Response to National Grid Assessment of the Colne Valley and Failure to Assess Cumulative Effects

Norwich to Tilbury Electricity Transmission Project (EN020027)

This submission concerns National Grid's assessment of the Colne Valley, including Fordham, Ford Street Conservation Area and Aldham.

**Appendix E
Action Point 27 –
Colne Valley
(including Fordham,
Ford Street, Aldham)
Constraints and
Opportunities Plans**

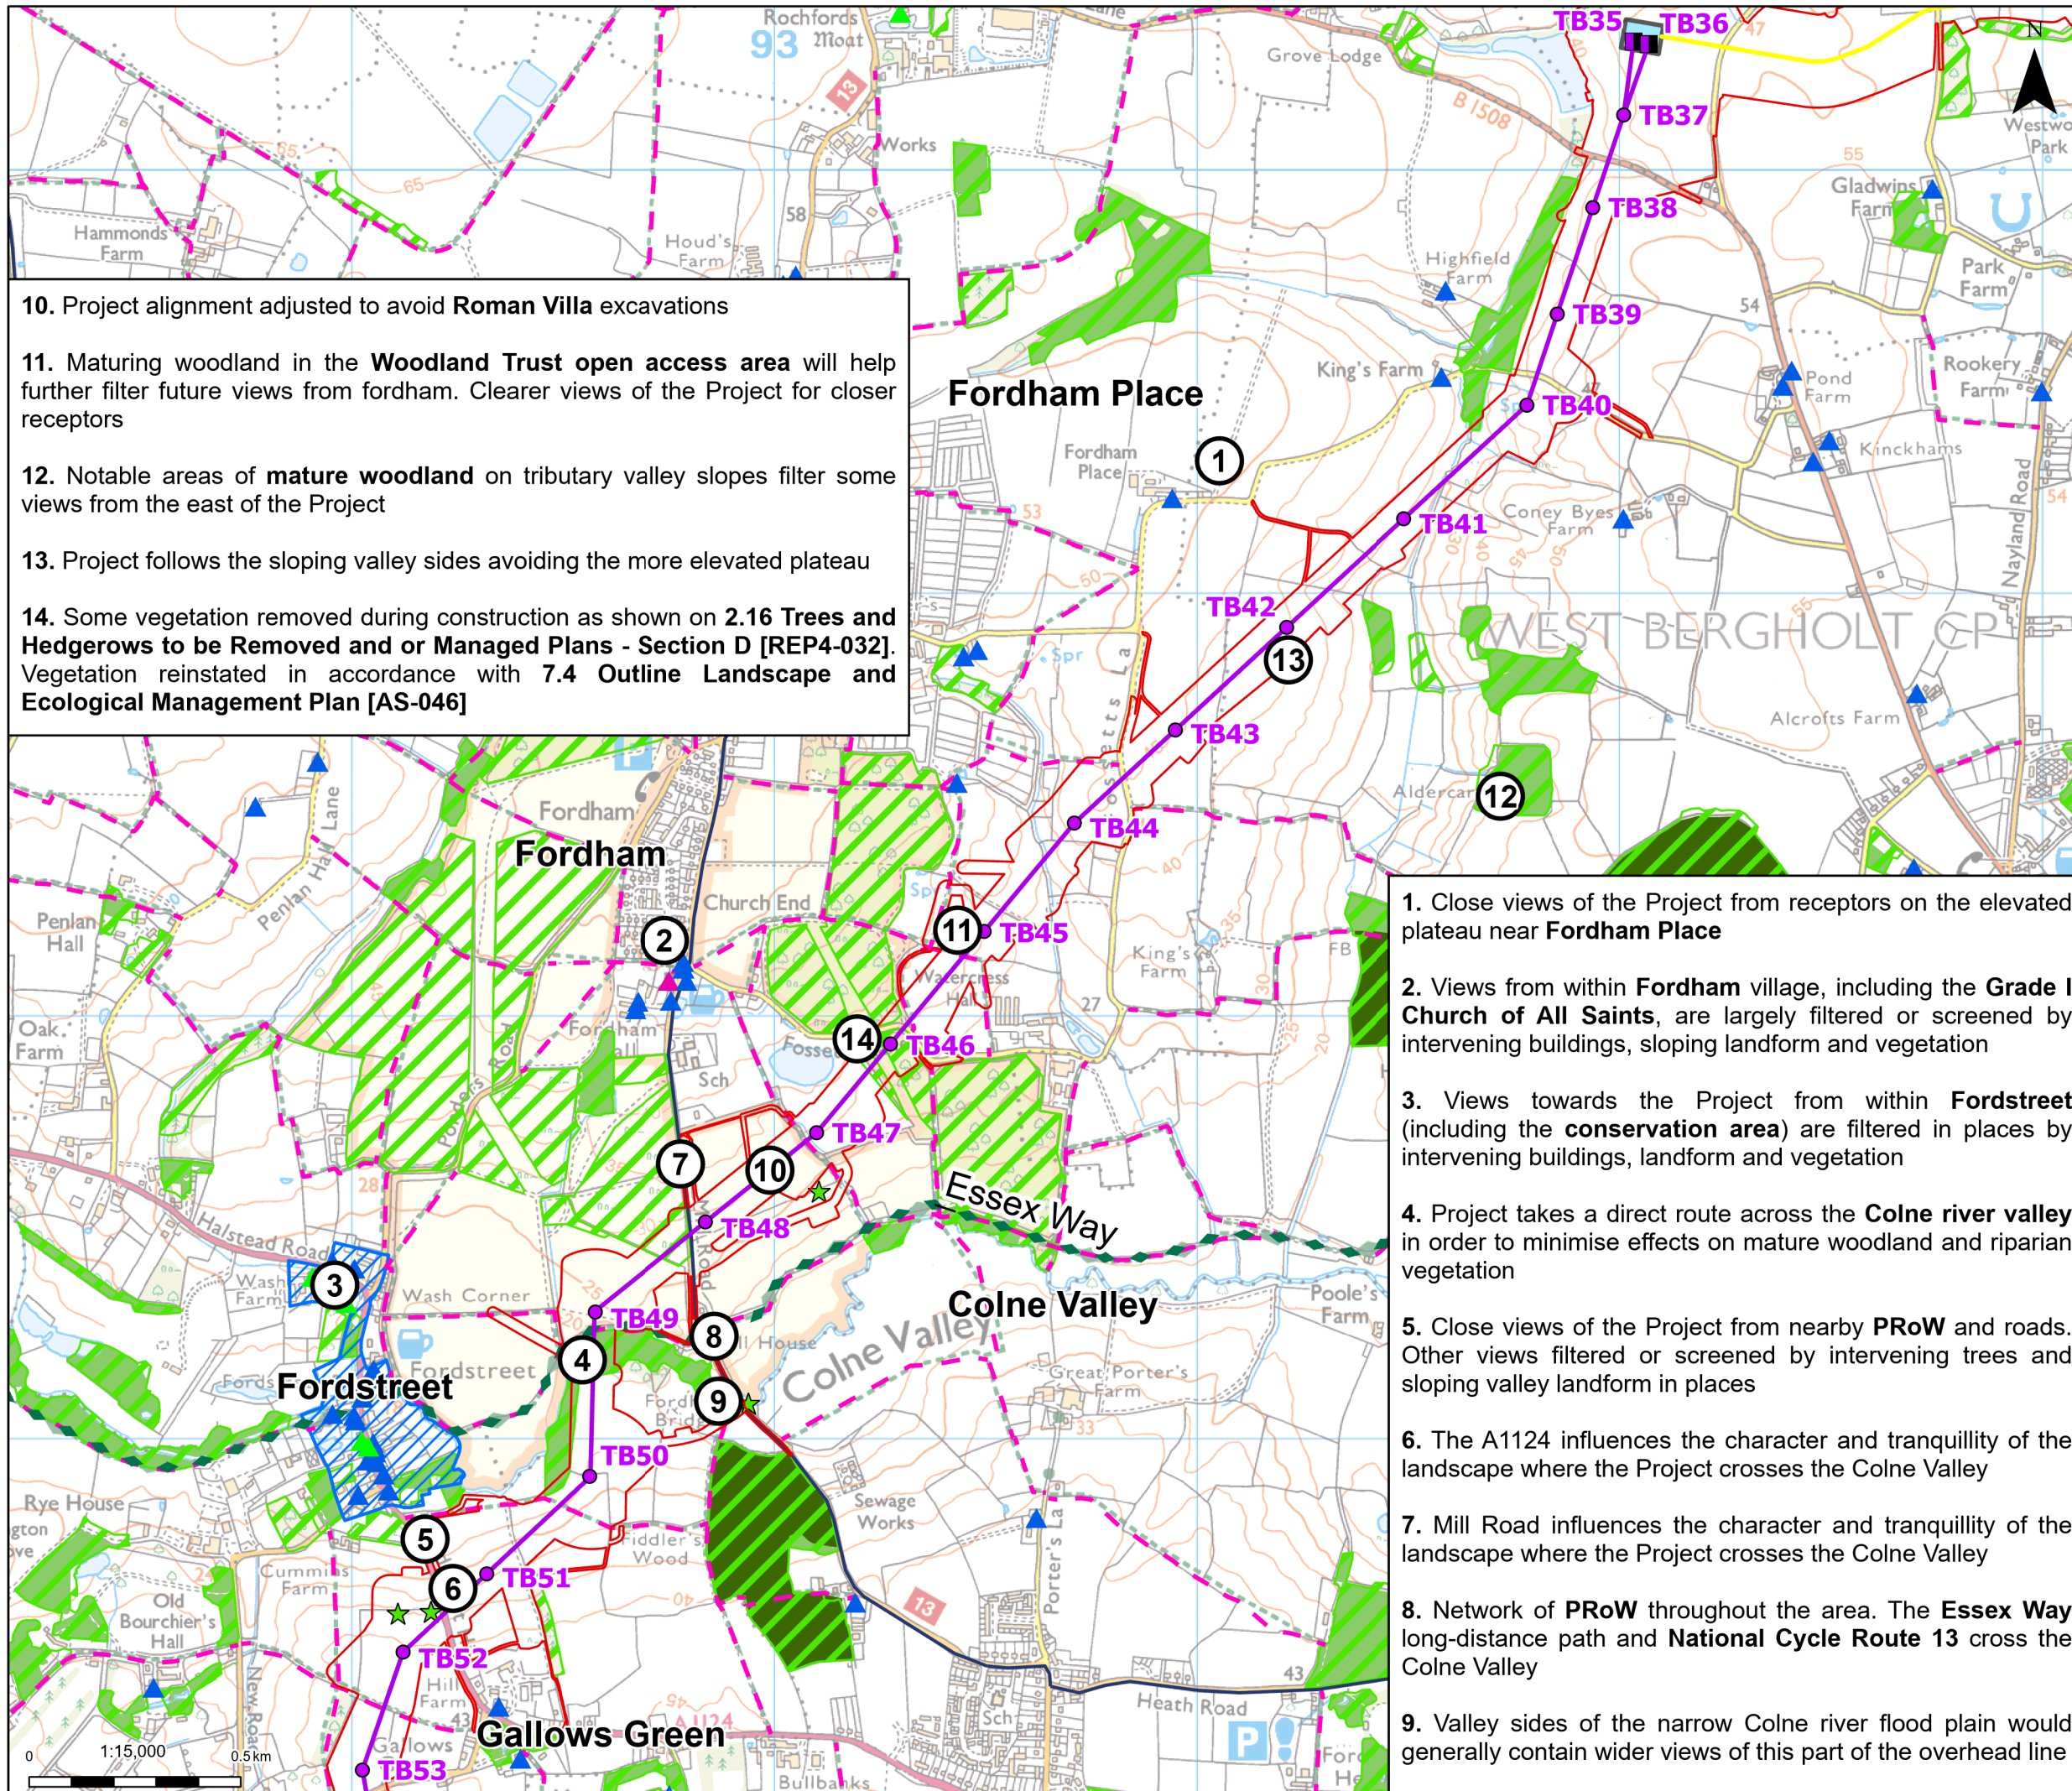
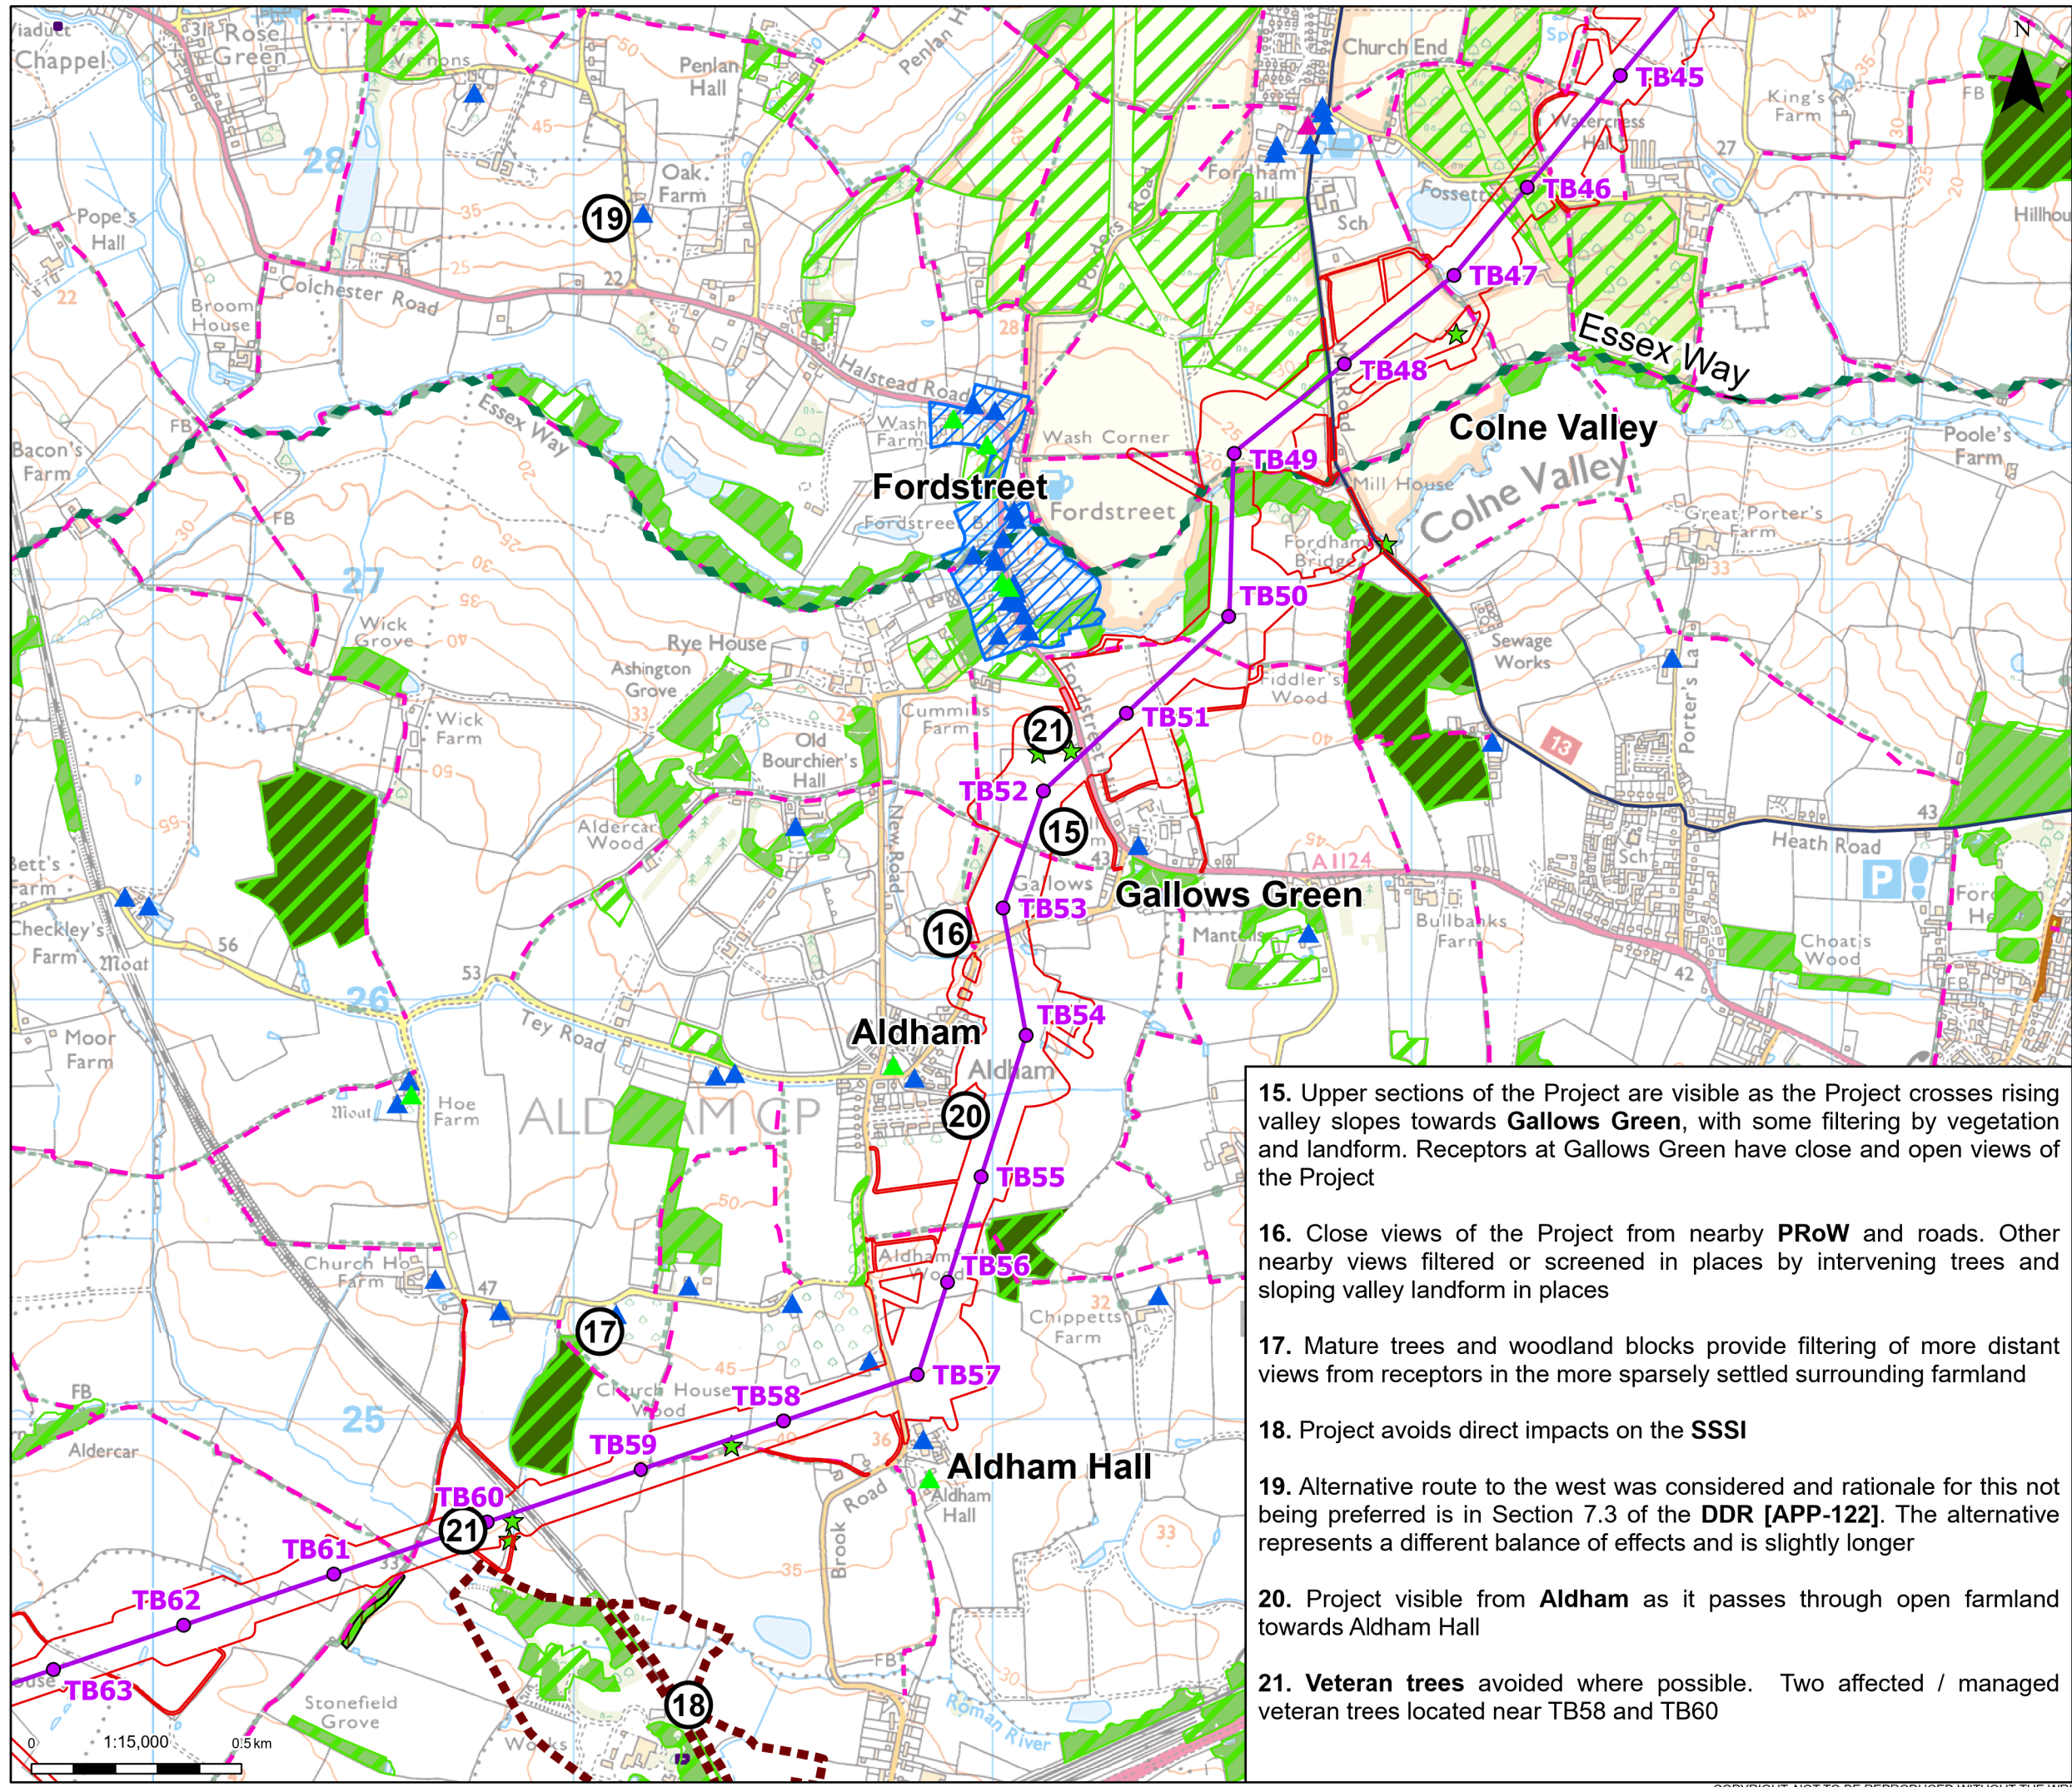
Most significantly, at LV 1.28 the Examining Authority specifically requested coordinated masterplans for the Colne Valley (including Fordham, Ford Street and Aldham) incorporating landscape, ecology, archaeology, rights of way and built heritage. This request implicitly recognises that these matters should be assessed together rather than as separate environmental topics.

National Grid's response to ISH2 Action Point 34 does not provide the cumulative assessment sought by the Examining Authority. Instead, it describes routeing considerations, topography, woodland, archaeology and heritage constraints individually before concluding that alternative routes would merely represent a transfer of effects.

The central concern identified by the Examining Authority remains unanswered.

The Examining Authority has repeatedly identified concerns regarding cumulative effects, heritage impacts, landscape character, alternatives and the need for coordinated planning within the Colne Valley.

The Applicant has failed to address the fundamental concern raised throughout consultation and examination: whether the concentration of heritage, landscape, ecological, recreational and residential impacts within the TB046–TB057 corridor creates exceptional cumulative harm requiring a different route or greater use of undergrounding.
